Rezoning Petition Review

Rezoning Petition #: 21-026

Location of Property: Approximately 20.55 acres bound by the east side of Old Statesville Rd, the south side of Eastfield Rd.

CITY OF CHARLOTTE, MECKLENBURG COUNTY, NORTH CAROLINA  
FOR  
CIVIL CONSTRUCTION DOCUMENTS  
HENDRICK NORTH LAKE  
REZONING SITE PLAN

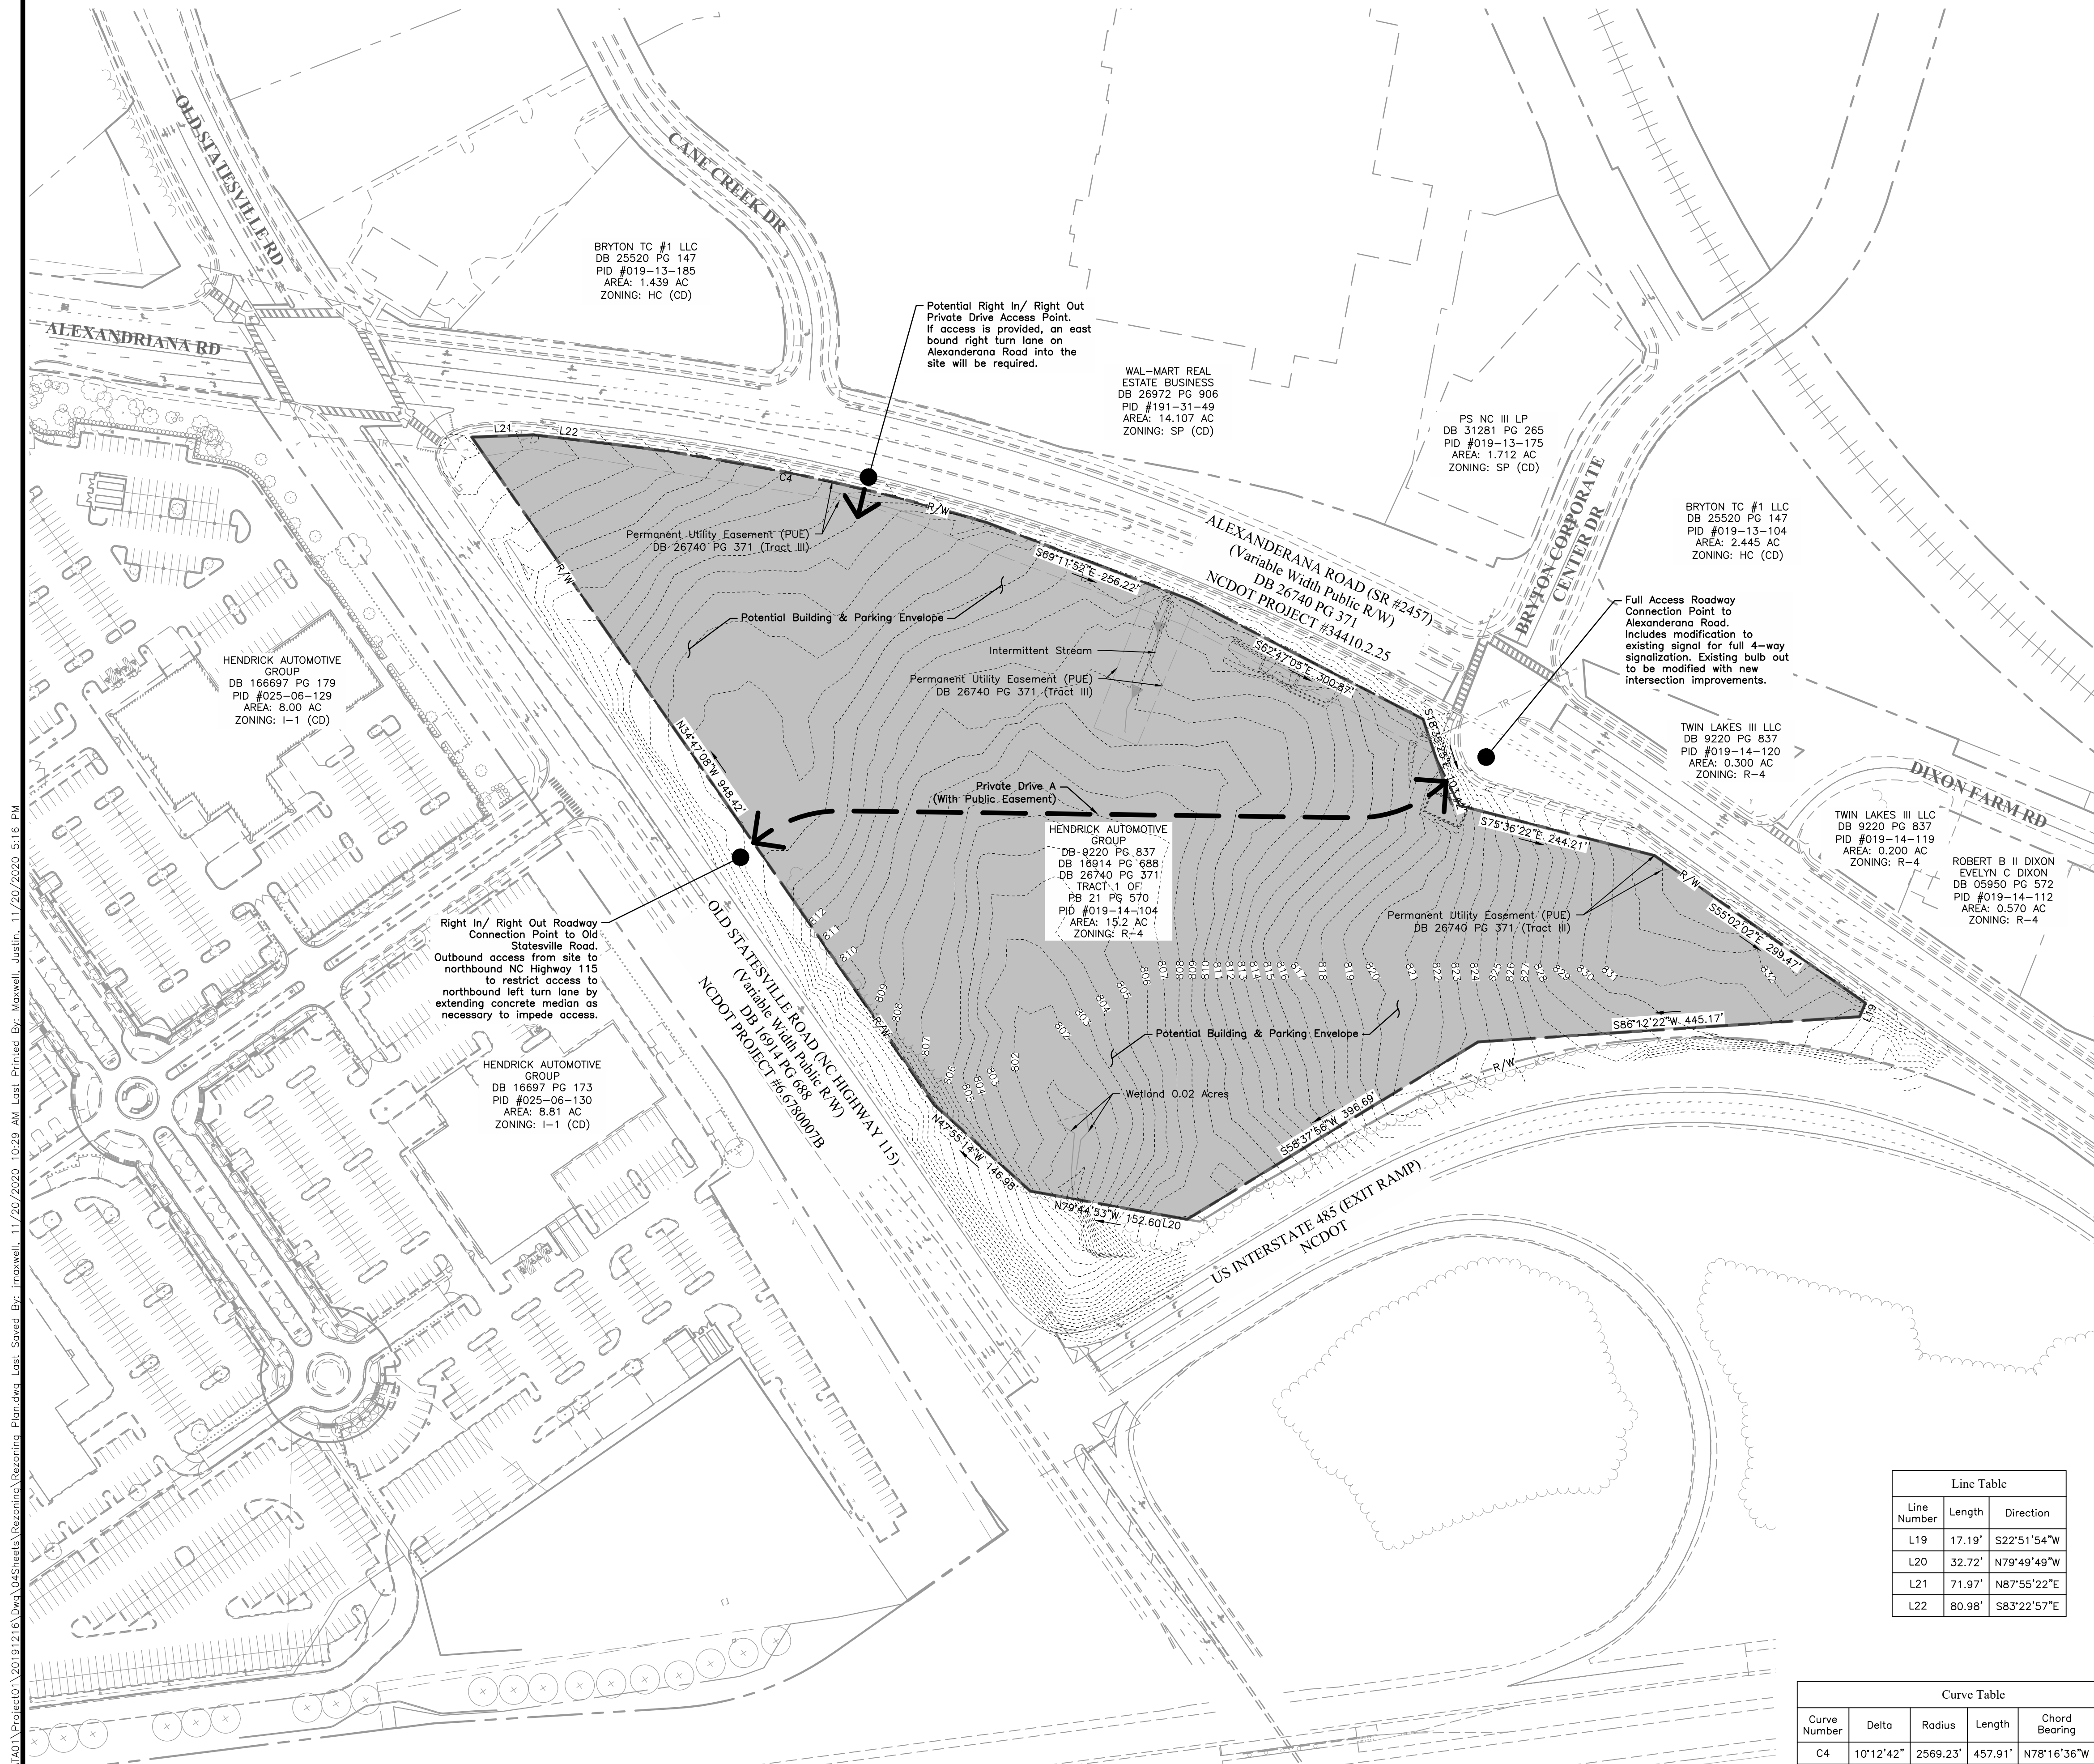
Recommendations Concerning Storm Water: The rezoning plan sheet indicates an intermittent stream on site. Please note perennial and intermittent streams require PCSO Buffers. Please include the following note under Environmental Features: *“Development within any SWIM/PCSO Buffer shall be coordinated with and subject to approval by Charlotte-Mecklenburg Storm Water Services and mitigated if required by City ordinance. Petitioner acknowledges intermittent/perennial stream delineation reports are subject to review and approval upon submission of development plans for permitting and are not approved with rezoning decisions.”*
